Moonee Beach Residential Subdivision (SSD 7198)
Request for Additional Information

The Department has received a submission from the Biodiversity Conservation Division (BCD) on the Response to Submissions, dated 6 July 2020, for the above State significant development application.

Figure 7 | Buffer to Moonee Creek top of bank (Source: Applicant's RTS July 2020) Figure 8 | Buffer to Moonee Creek on site to South (Source: 0457/18DA)

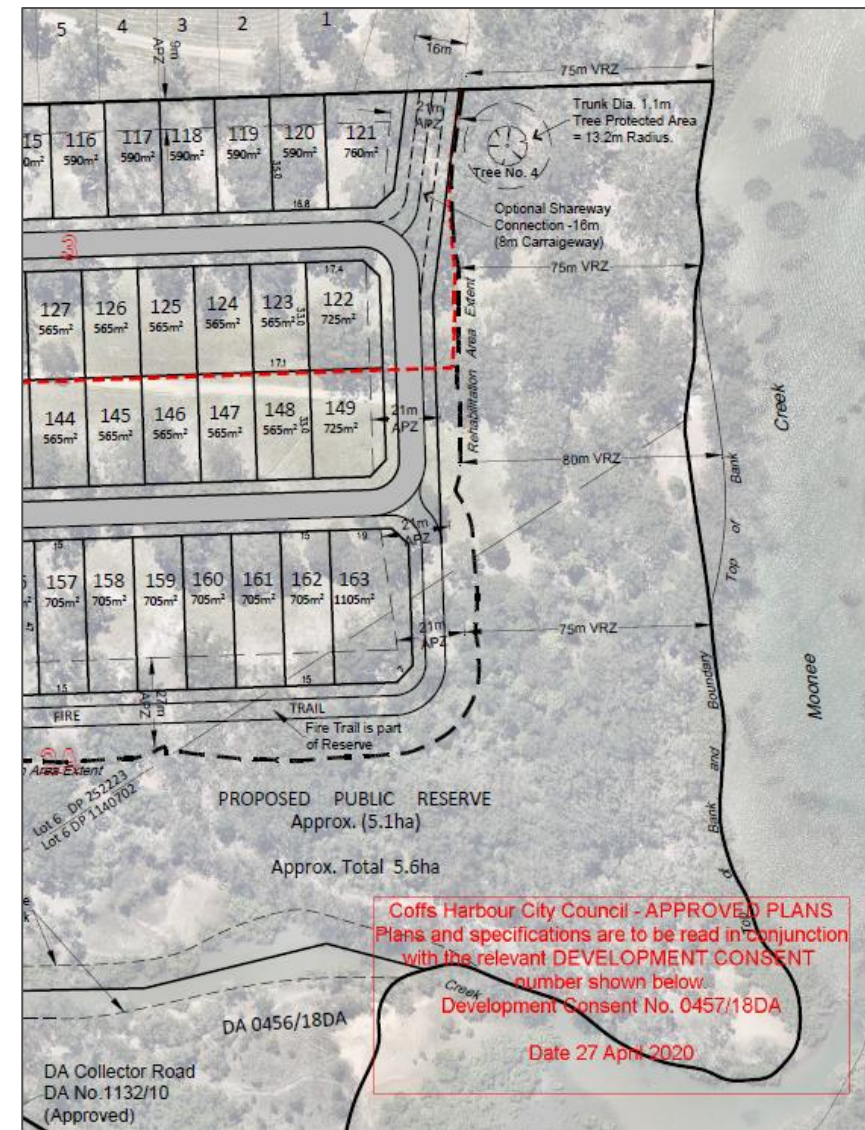
- a plan showing the full extent of a 72m average buffer from the creek edge over the currently proposed scheme, together with the buffer width on adjoining developments to the north and south
- a plan showing an amended layout (without changing the road connection to the south) that provides a 72m average buffer from the creek edge, together with the buffer width on adjoining developments to the north and south
- a summary of the changes proposed to the Biodiversity Offset Strategy, and clarification and justification for the proposed reduction in the number of credits
- a staging plan outlining the number of credits to be retired at each stage.
